# CITY OF PORTLAND BUILDING PERMIT

**PERMIT ID:** 2017-00980

has permission to **AMENDMENT 1 to 2016-02535 - Change painted PVC infill to thinbrick infill - Middle & Market St facades**

| <b>Proposed Use:</b><br>Same: Retail (West Elm Furniture)   |                                      | <b>Proposed Project Description:</b><br>AMENDMENT 1 to 2016-02535 - Change painted PVC infill to thinbrick infill - Middle & Market St facades |  |   |

# West Elm Side Elevation (Market St)

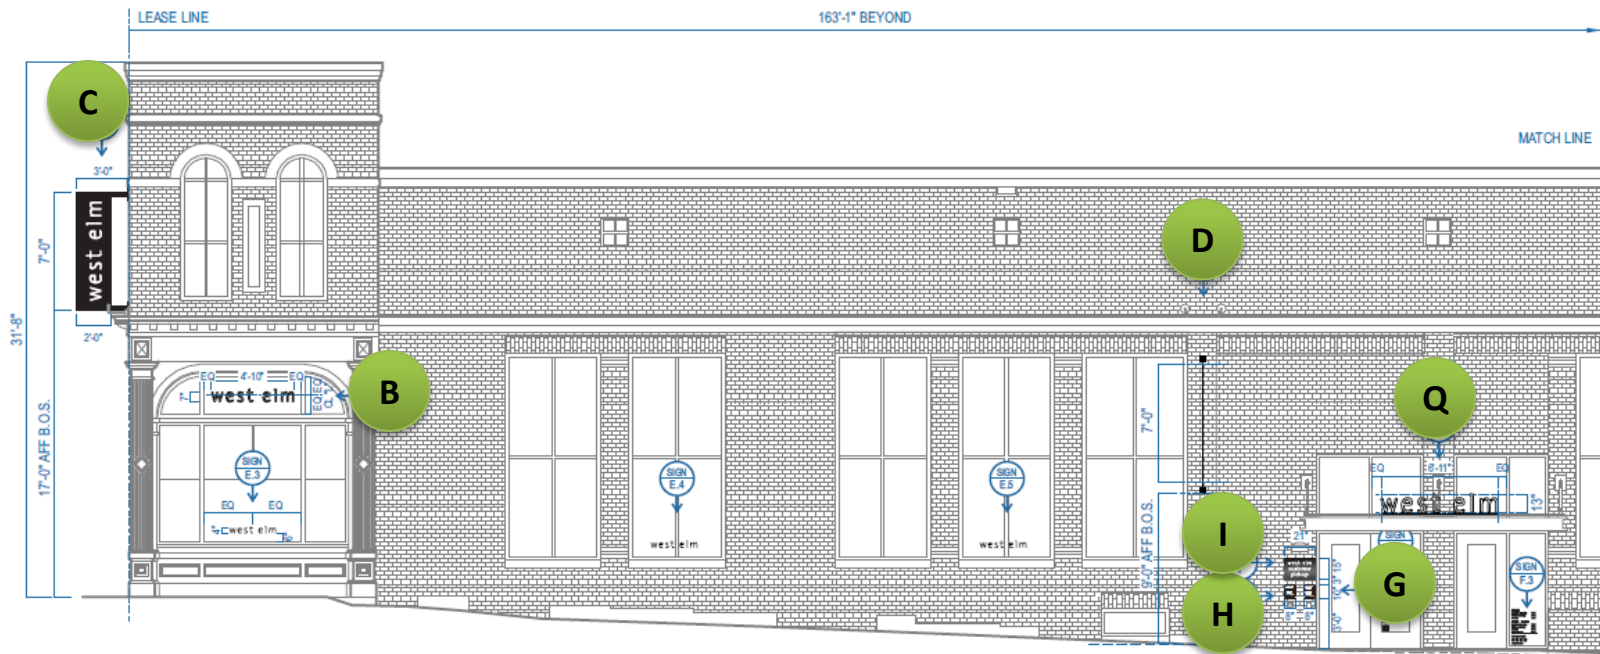
| 3) Masonry infill panels are to be as viewed in the mockup reviewed by HP staff with Pete Chavonelle, not as submitted by architect in permit addendum dated 6/15/17. No metal mesh or backer is to be used behind the thin brick. The face of the thin brick infill is to be as far back as possible from the plane of the wall.   |                                      |  |  |   |
